Your reference : 05_0198
Our reference : FIL06/2036-05 DOC09/40838
Contact : Peter A. Ekert, 66402514 peter.ekert@environment.nsw.gov.au

**RE: ENVIRONMENTAL ASSESSMENT EXHIBITION– Major Project Application 05_0198
Proposed Residential Subdivision of Lot 1 DP134787, Lot 1 DP 167380, Lot 2 DP 961928,
and Part Lot 4 DP 1054848 at Walmsley Road and Stott Street, Bilambil Heights**

Attachment 1

DECCW's Assessment

LEVEL DATUM	SCALE 1: 1250 REVISION F SHEET 1 OF 3 JOB No 35054
DATE OF SURVEY	
DATE 04.05.11	
DRAWN GMB	
CHECKED BG	
CAD FILE No. 35054-PROP

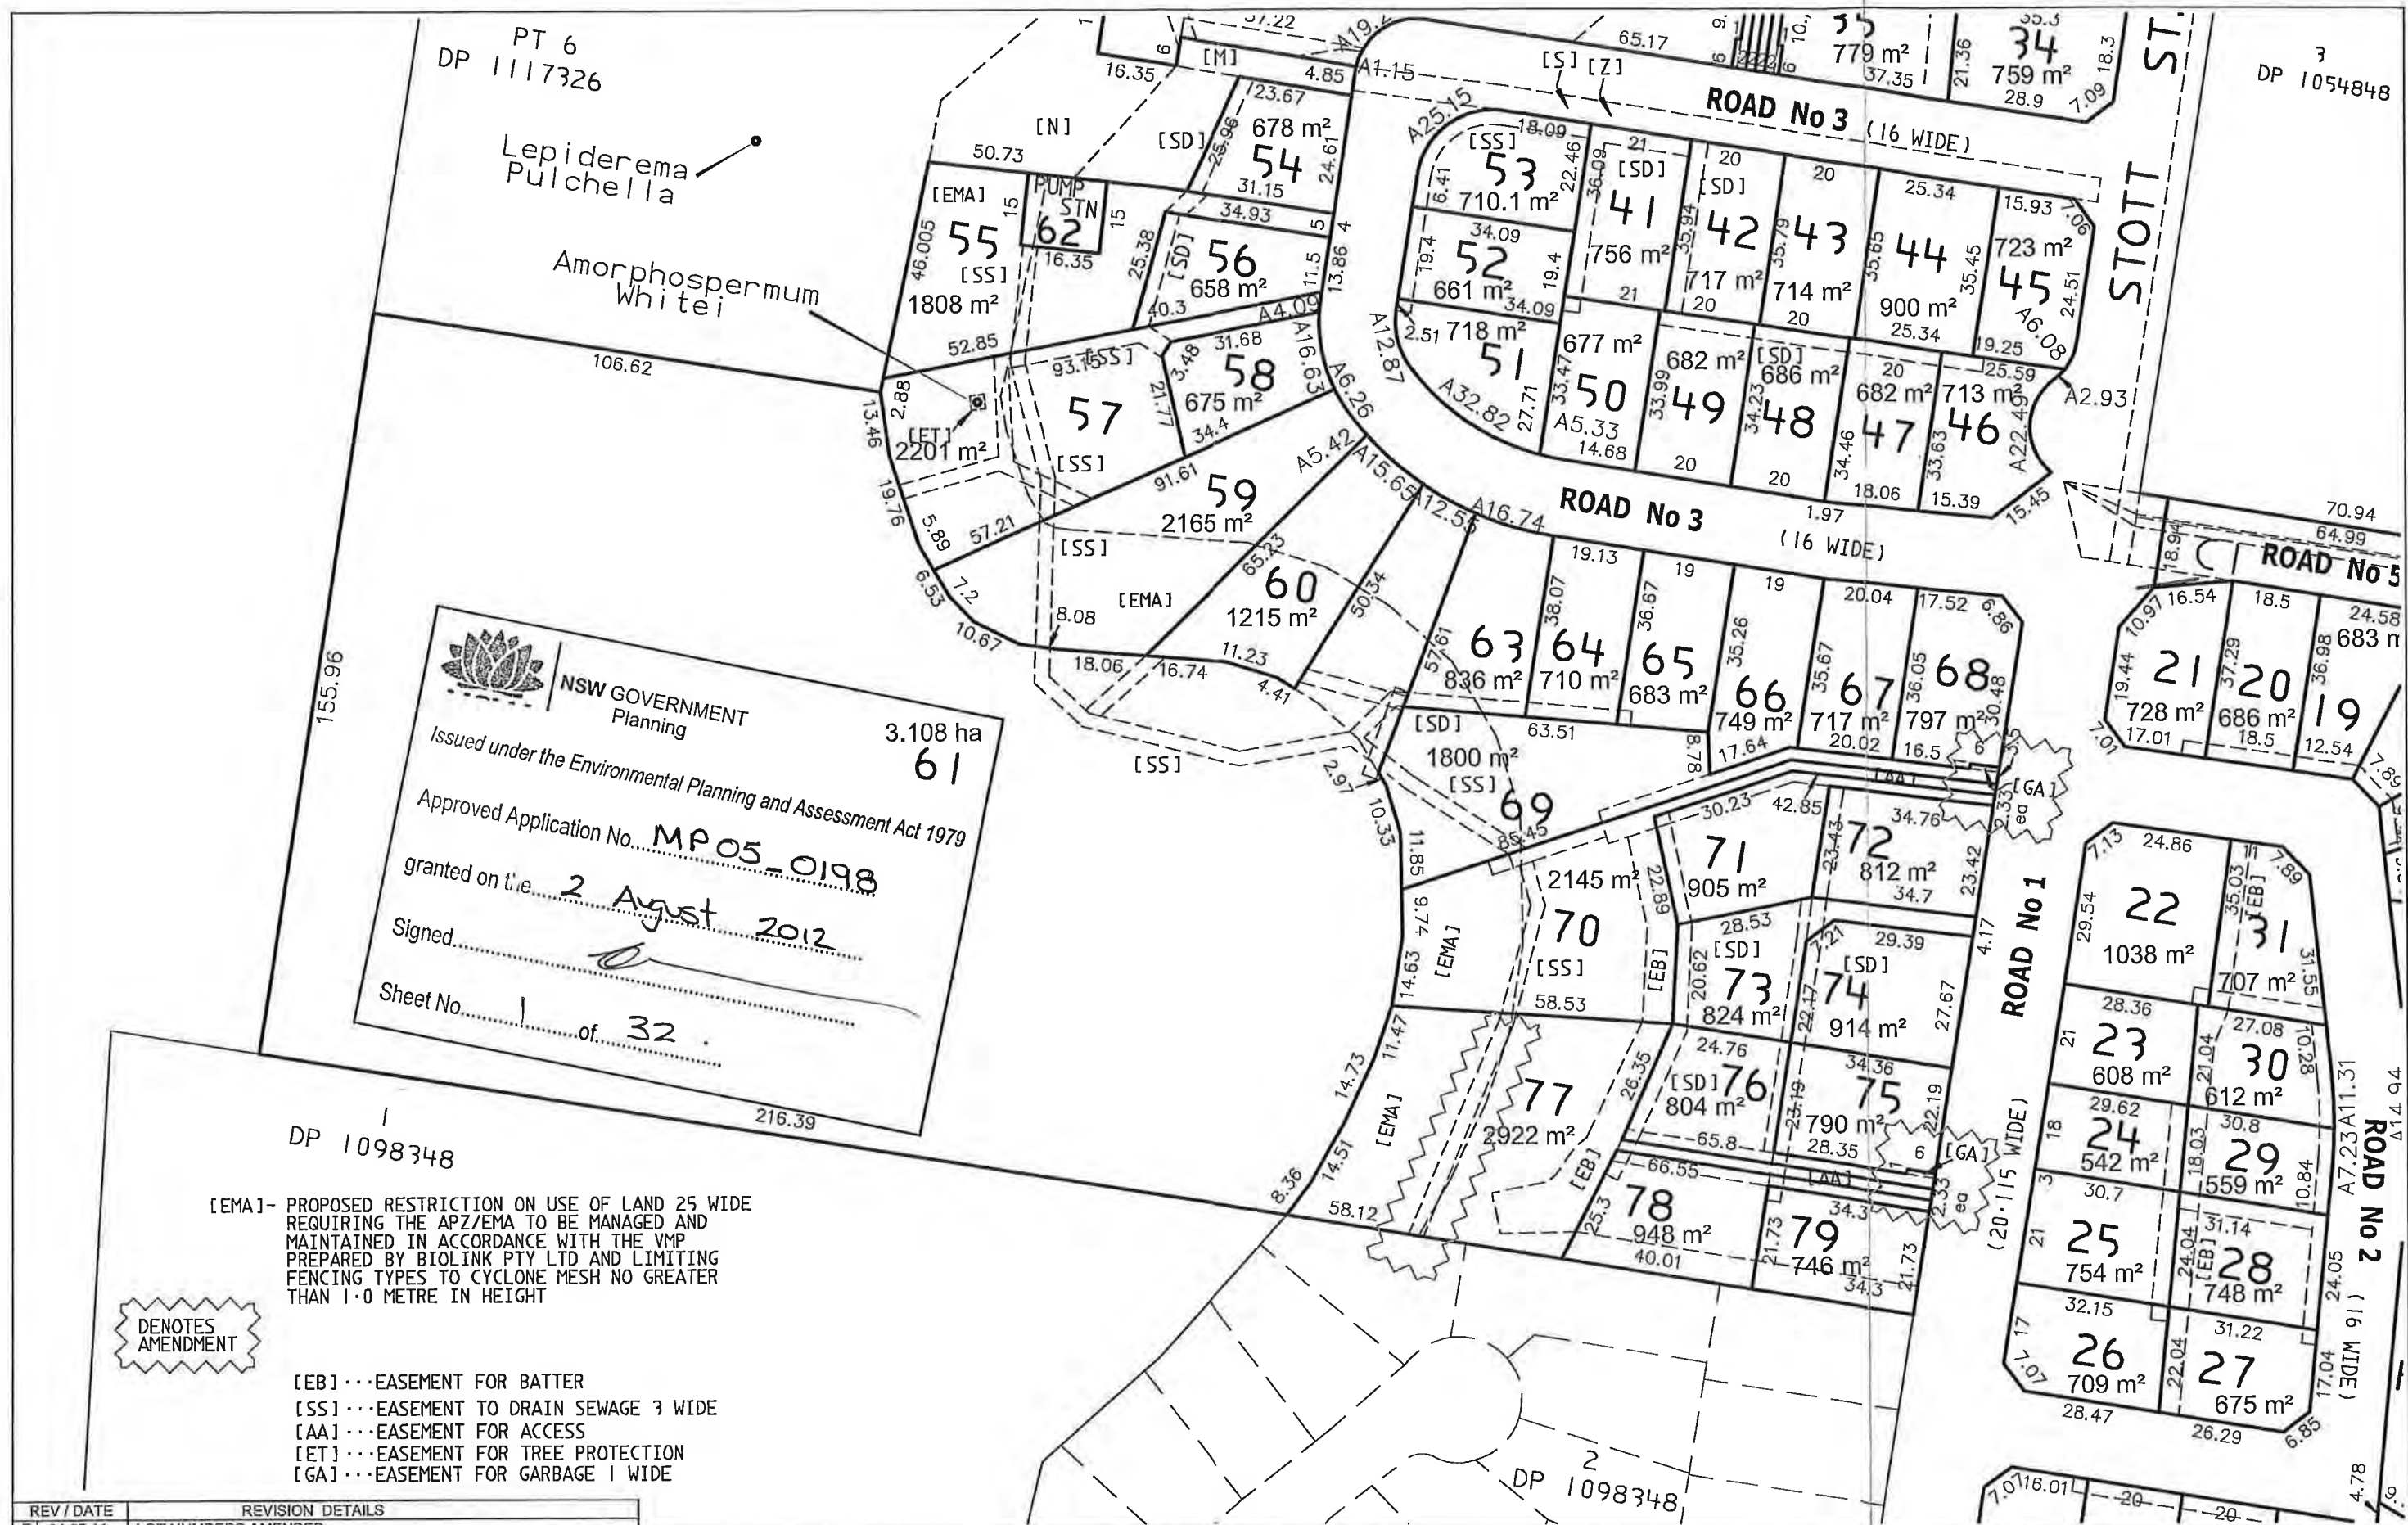
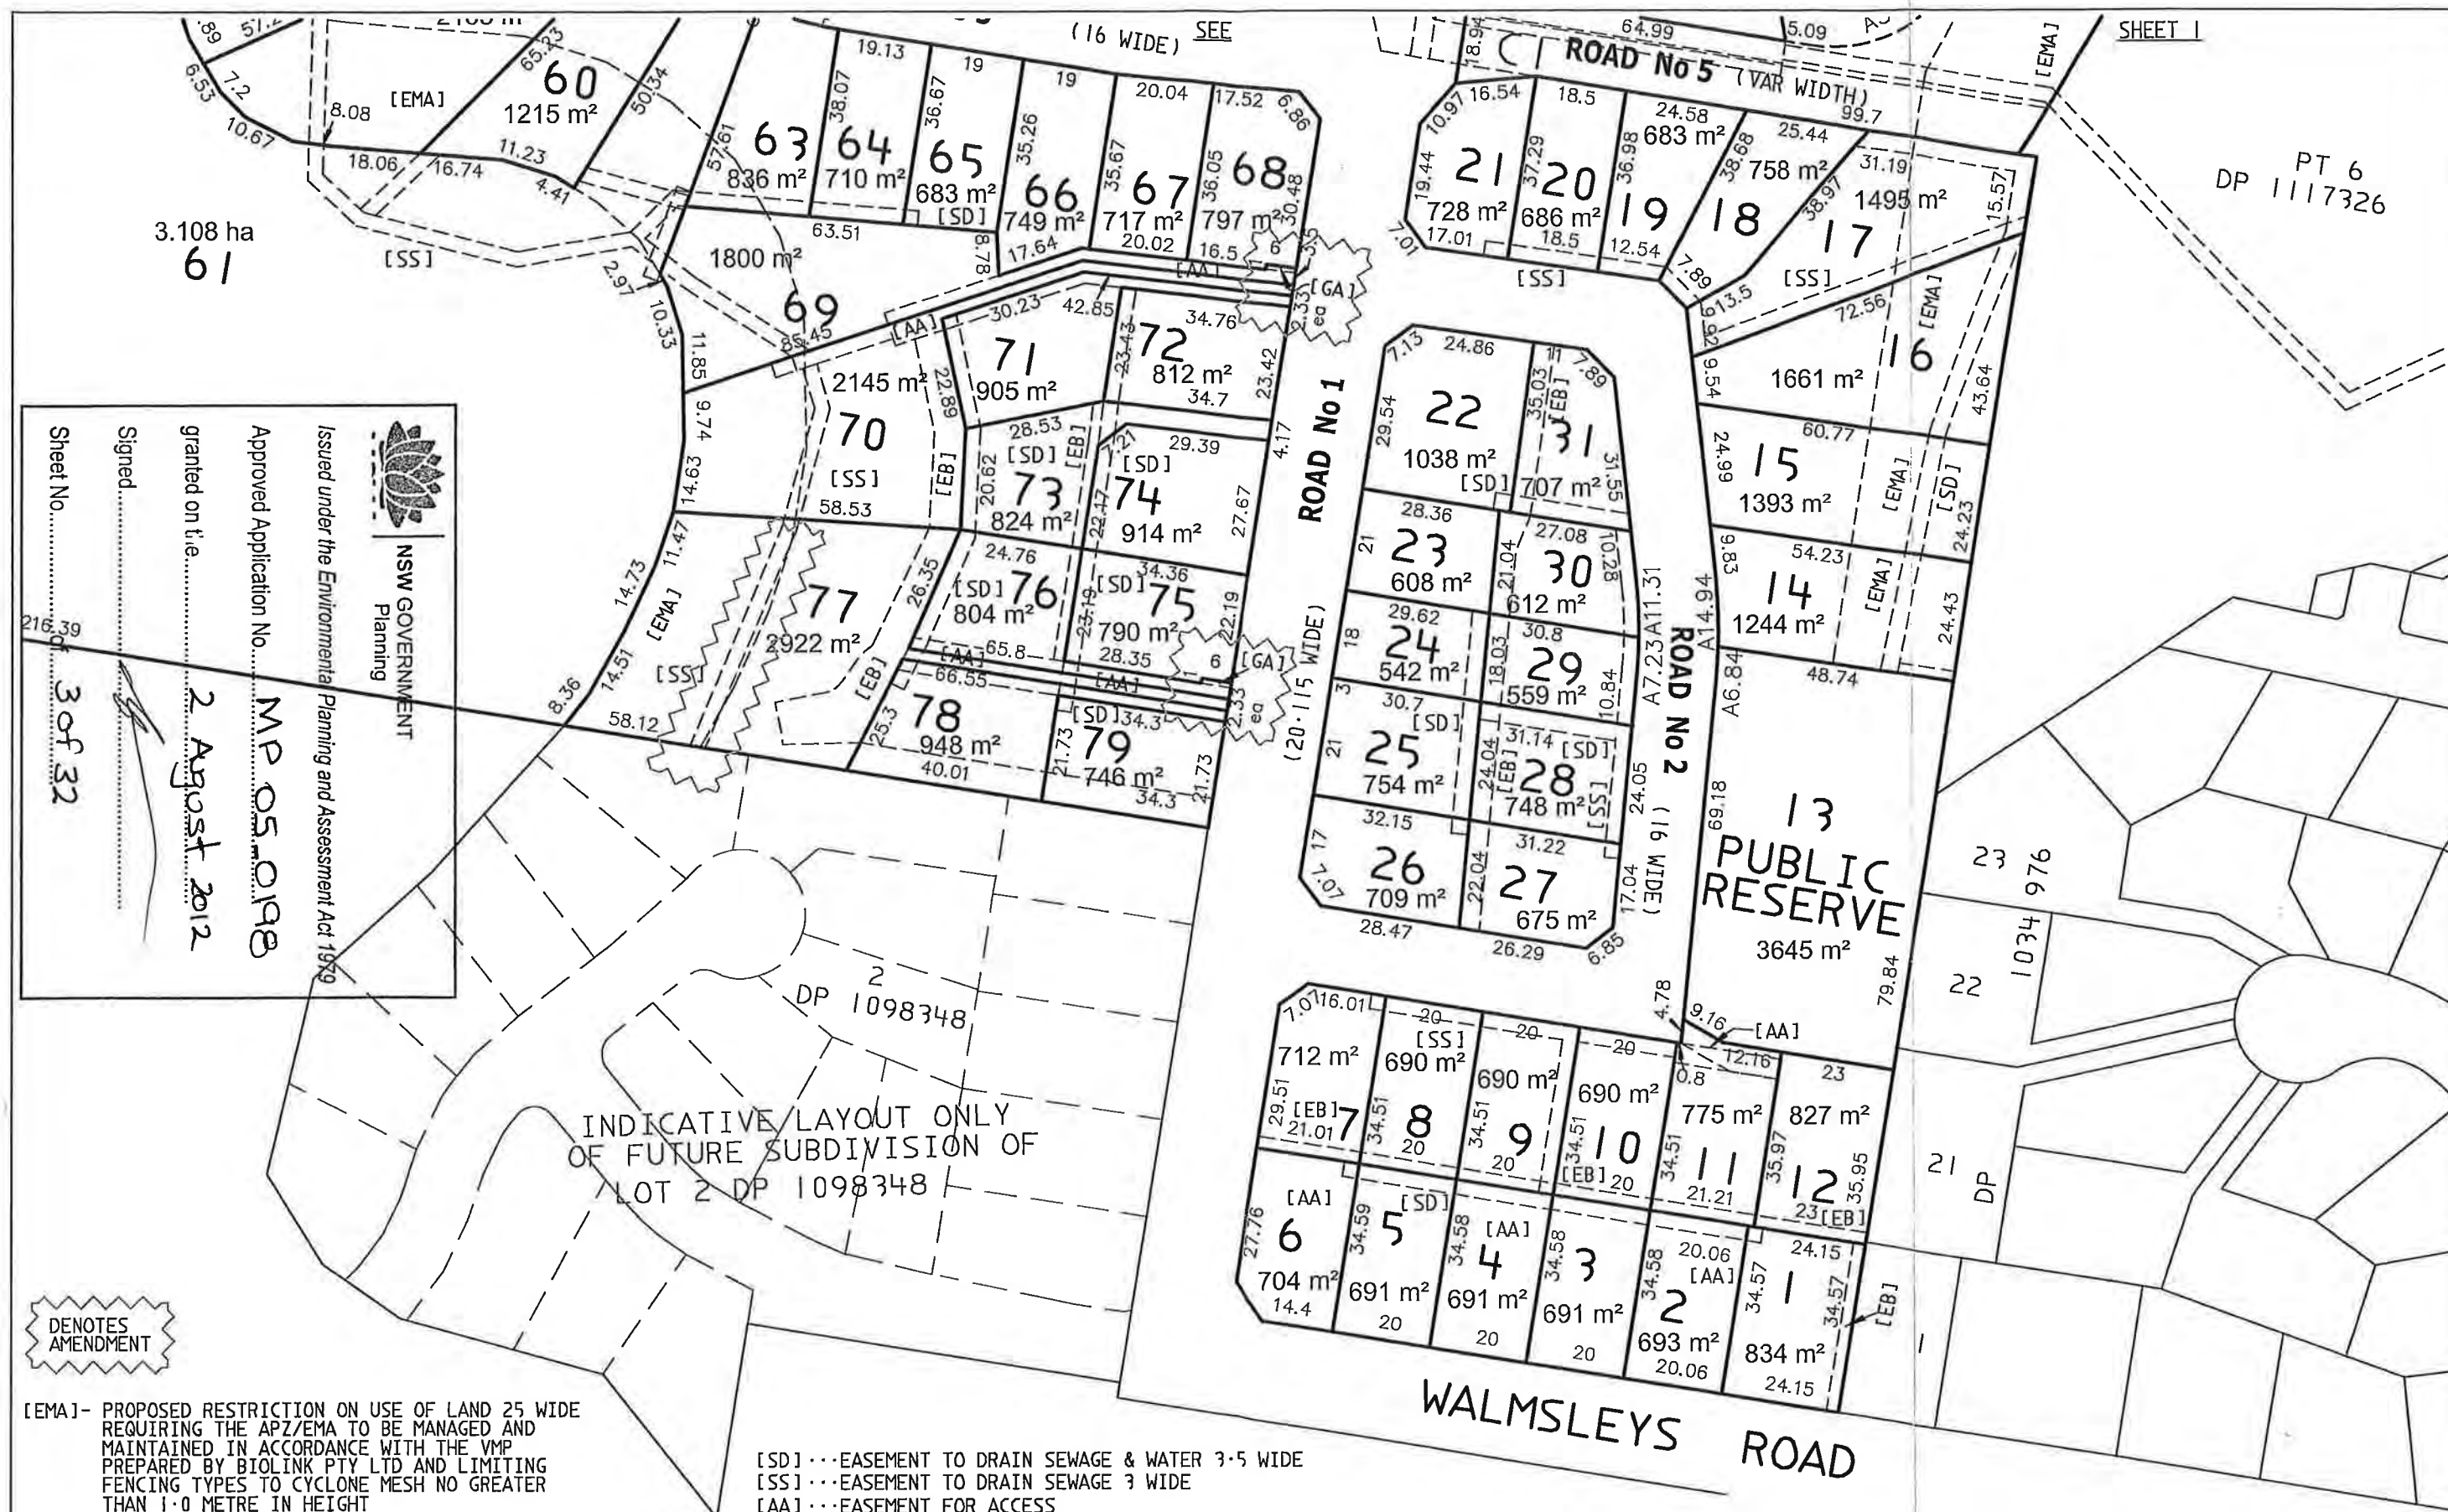
DECCW is concerned that the existing subdivision design and layout will impact on EEC's. In particular the Lots 38, 39, 41 and 42 as presently designed will encroach on an EEC. DECCW recommends that the layout of these four lots be re-designed so that the already fragmented EEC will not be further impacted on. The re-design should also incorporate a buffer from the edge of lot to the EEC, so that any impact from urbanisation is minimised.

4. As indicated in DECCW's correspondence dated 27 October 2009, DECCW considers that no part of the EEC should be cleared/removed from the property and all EEC areas should be buffered. DECCW routinely advocates a 50 metre vegetated buffer for all EECs. A reduced buffer distance may be acceptable if it can be adequately justified, however the current proposal of no buffer at all (apart from a 25m grassed APZ) is not an acceptable or justified buffer to the EEC.
